Acceptance of Applications Checklist

Boston Alternative Energy Facility Section 55 Acceptance of Applications Checklist

Section 55(2) Acceptance of Applications				
1	Within 28 days (starting day after receipt) the Planning Inspectorate must decide whether or not to accept the application for Examination.	Date received	28 day due date	Date of decision
		23 March 2021	20 April 2021	20 April 2021
Section 55(3) – the Planning Inspectorate may only accept an application if it concludes that:			Planning Inspectorate comments	
Section 55(3)(a) and s55(3)(c): It is an application for an order granting development consent				
2	Is the development a Nationally Significant Infrastructure Project ¹ (NSIP) (or does it form part of an NSIP); and does the application state on the face of it that it is an application for a Development Consent Order ² (DCO) under the Planning Act 2008 (the PA2008), or equivalent words? Does the application specify the development to which it relates (i.e. which category or categories in ss14 to 30 does the Proposed Development fall)?	<p>Yes.</p> <p>The Proposed Development set out in Schedule 1 of the Draft DCO (Doc 2.1) includes development falling within the c

TITLE  
BOSTON ALTERNATIVE ENERGY FACILITY  
DEVELOPMENT CONSENT ORDER  
Regulation 5(4) - Key Plan  
Illustrative Landscape Plan  
BOSTON BOROUGH COUNCIL  
SHEET 1 OF 1

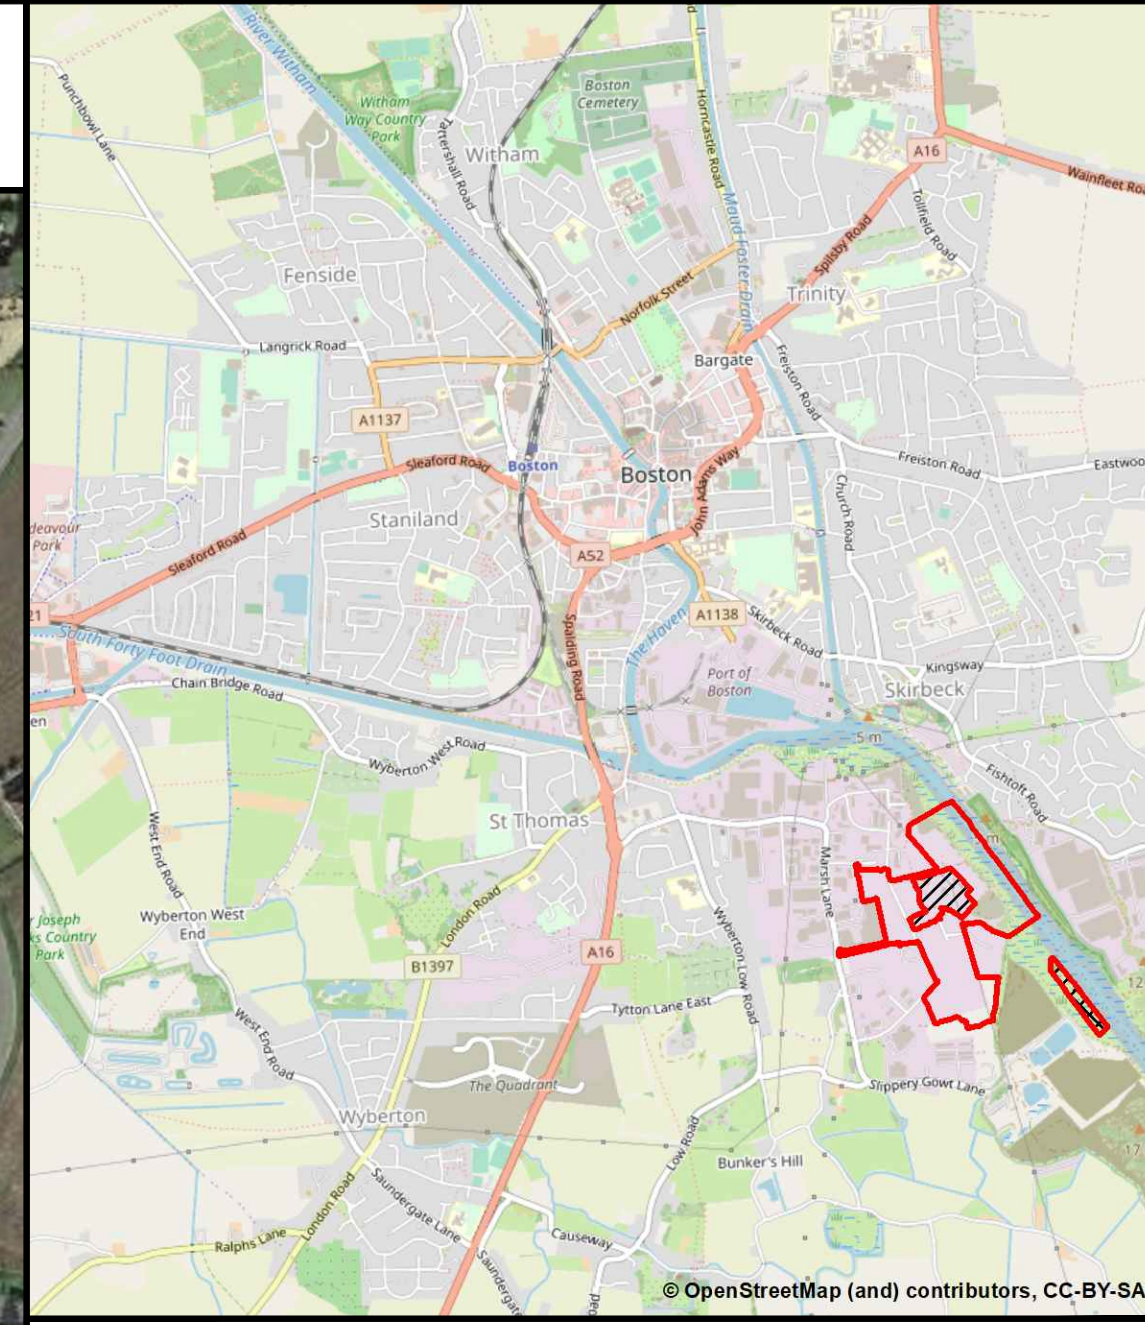
<p>On the key plan 'SHEET 5 OF 7' should refer to 'SHEET 5 OF 8'.</p> <p>Section 51 advice has been issued to the Applicant in respect of the above matters:</p> <p>https://infrastructure.planninginspectorate.gov.uk/projects/north-east/boston-alternative-energy-facility-baef/?ipcsection=docs&stage=2</p>	
31	<p>Is the application accompanied by a report identifying any European site(s) to which Regulation 48 of The Conservation (Natural Habitats, &c.) Regulations 1994 applies; or any Ramsar site(s), which may be affected by the Proposed Development, together with sufficient information that will enable the Secretary of State to make an appropriate assessment of the implications for the site if required by Regulation 48(1)?¹⁴</p>	<p>Yes.</p> <p>A Habitat Regulations Assessment (HRA) Report is provided at Appendix 17.1 of the Environmental Statement (Doc 6.4.18).</p> <p>The HRA Report identifies relevant European sites and the likely effects on those sites. It is considered that the information provided in the report is adequate for acceptance.</p> <p>Note: The Examining Authority will be able to ask questions during the Examination. This may result in additional information being required to inform the HRA Report and the competent authority. Depending upon the type and availability of information required it may not be possible to obtain this during the statutory timetable of the Examination.</p>
